Our Ref: P10002622
12 August 2026

George Hotel, St George's Square, Huddersfield, HD1 1JA
Application No. 2026/91957

Summary

1 Proposed GA Elevation - John William Street
1 : 100

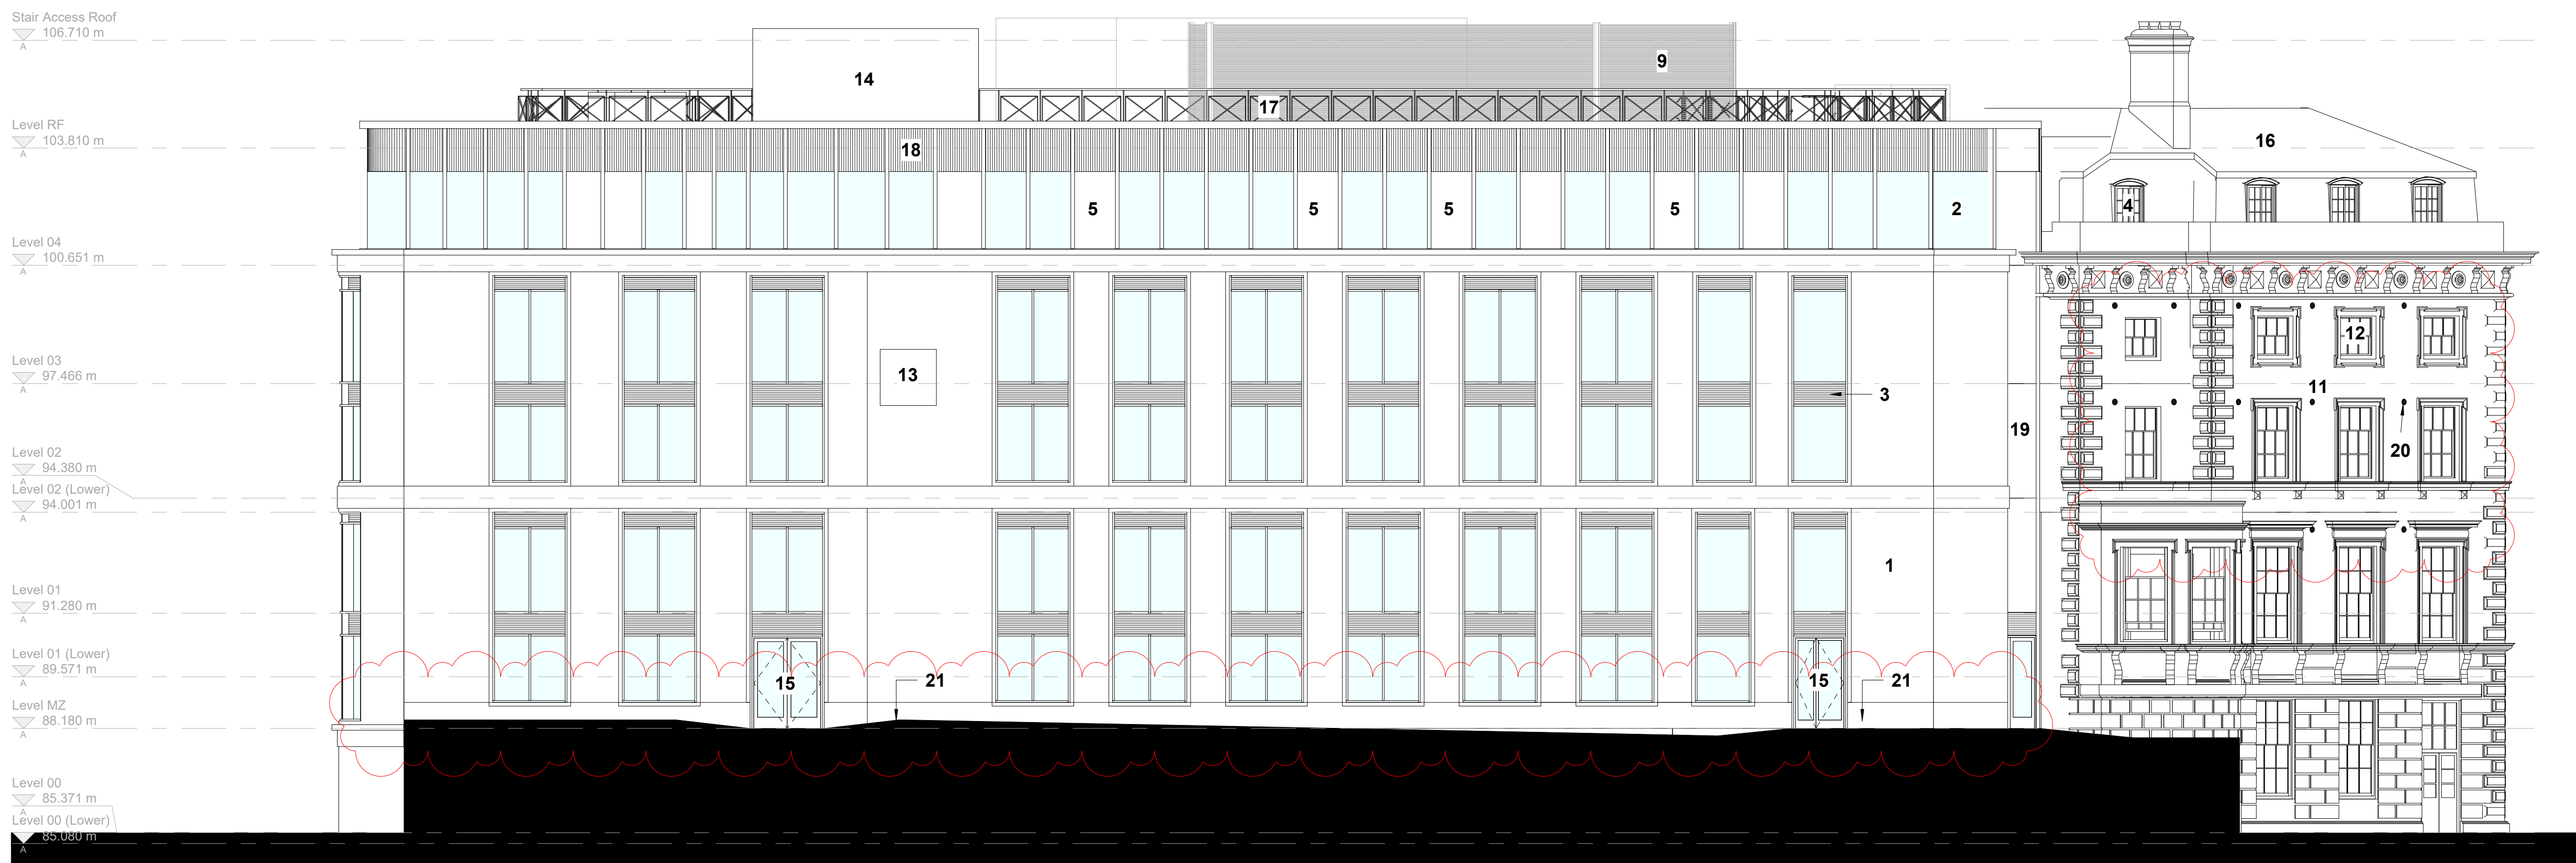
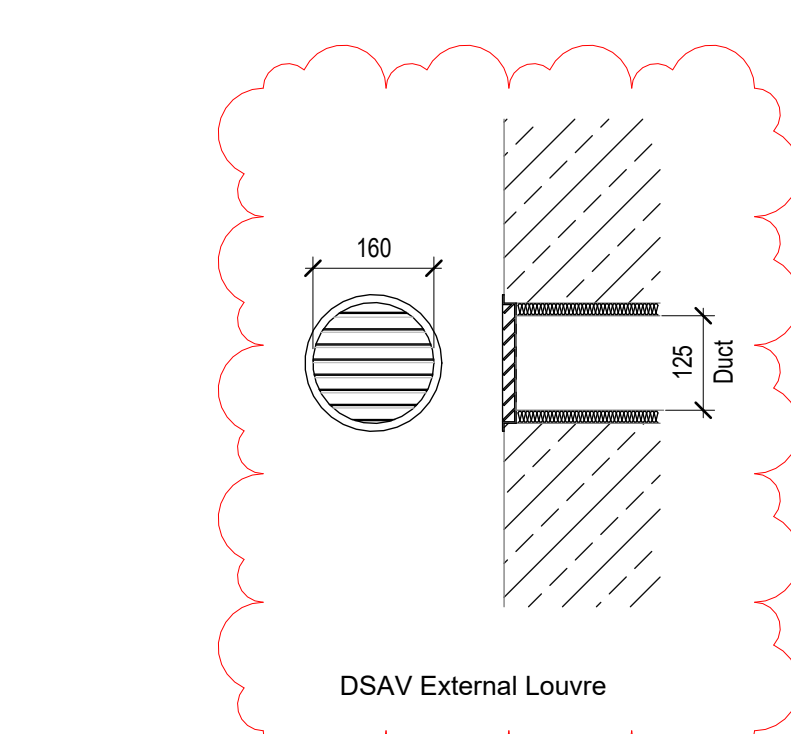
- The revised proposals include the reduction in scale of the roof top plant. In its place is a ventilation system, serving the guest bathrooms, with new circular vents to the elevations. Due to the high number of vents, the cumulative impact on architectural significance is notable. We would encourage consideration of a review of this scheme to remove or reduce the vents, particularly on the principle elevation fronting St George Square/Railway Street.

- If it is not possible to remove the vents from the scheme, advice on potential mitigation should be sought from the Council's conservation advisers.

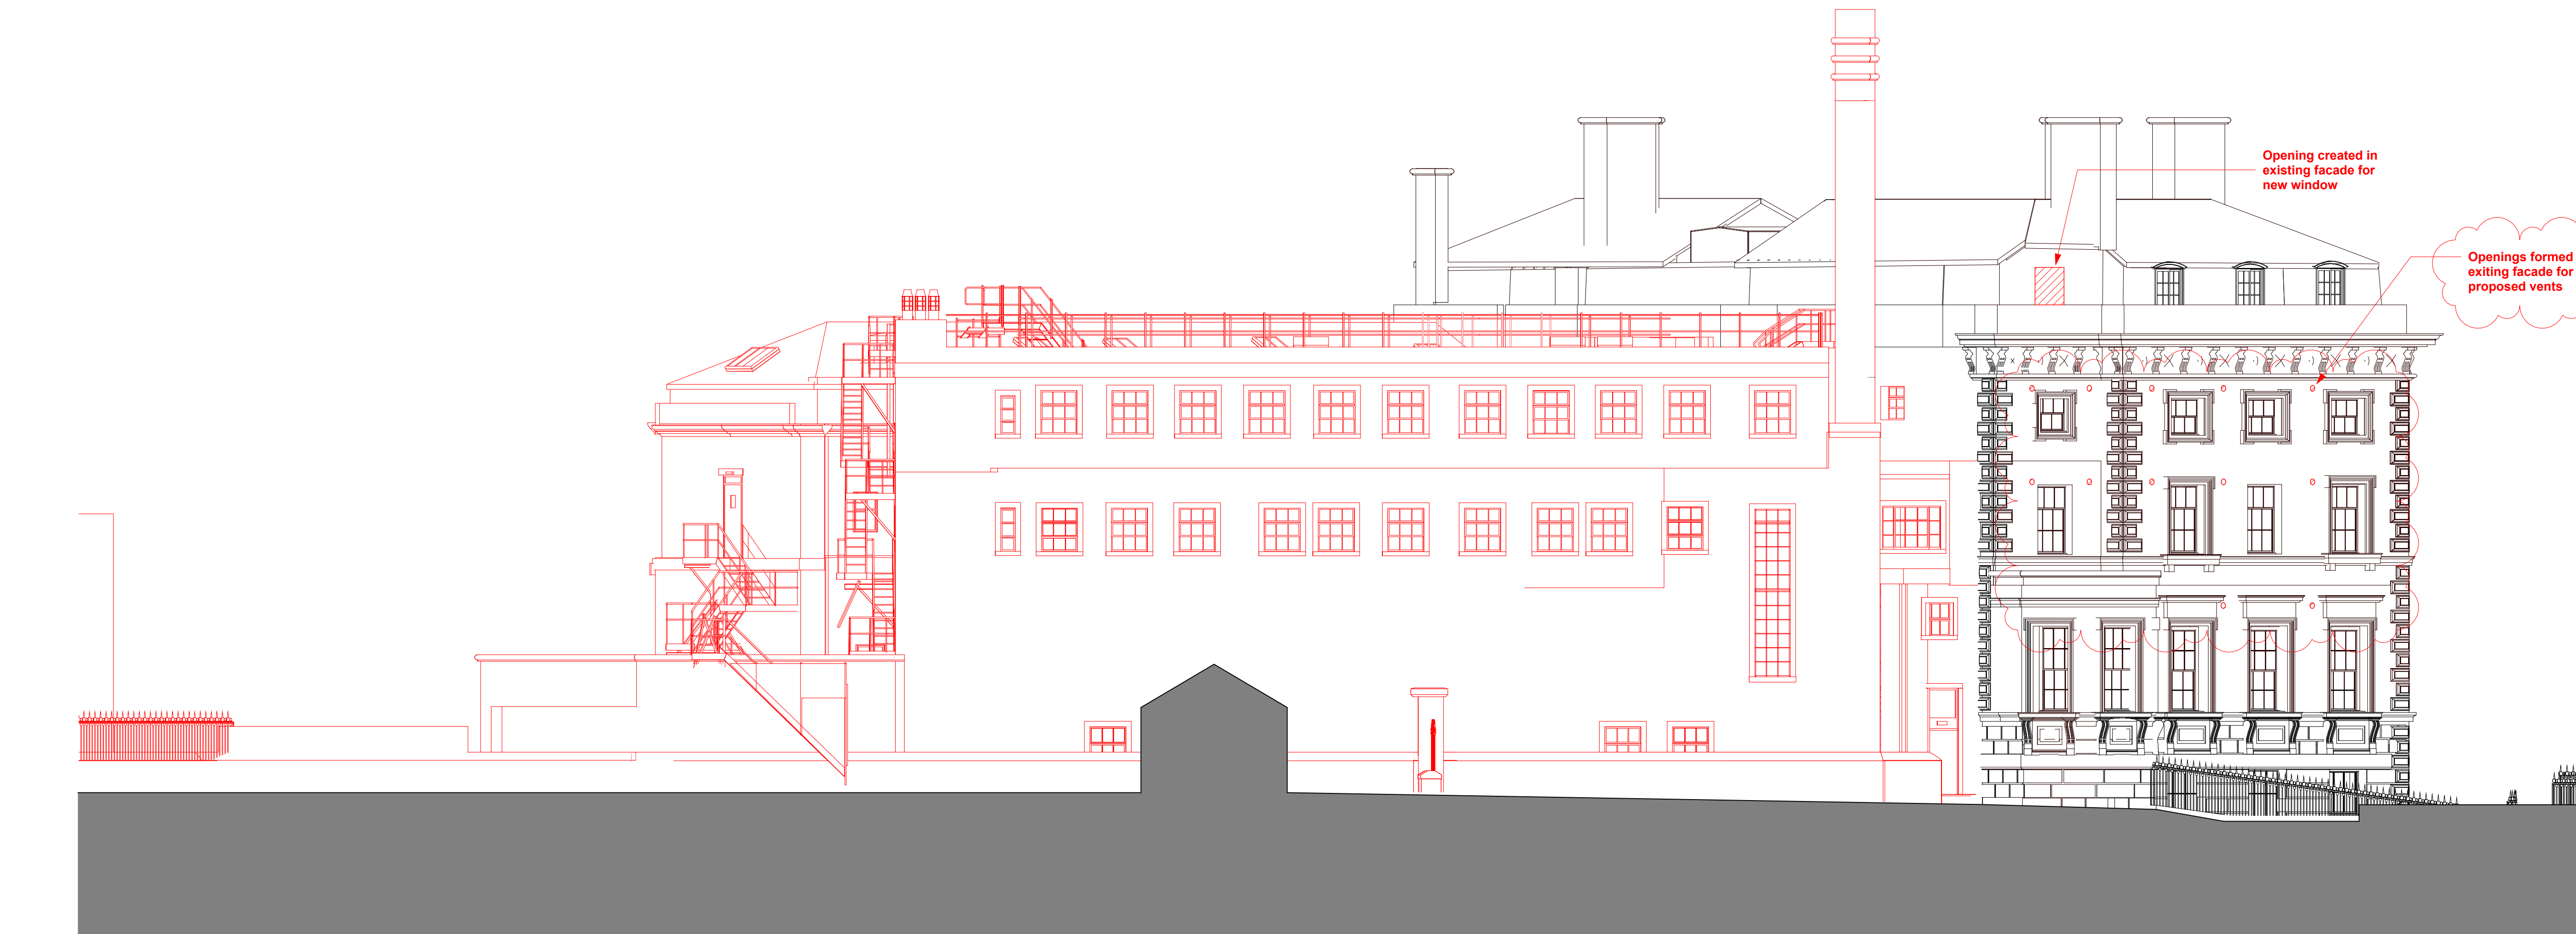
- The revised proposals will result in a increased loss of historic fabric, including features such as skirtings, doors, cornices and ceiling roses. Consideration should be given to alternative measures to allow retention of architectural features, whilst meeting the needs of the hotel. Historic England guidance is available online, such as Fire Resistance and Historic Timber Panel Doors: <https://historicengland.org.uk/images-books/publications/fire-resistance-historic-timber-panel-doors/life-sig-guide-fire-resistance-historic-timber-panel-doors/>.
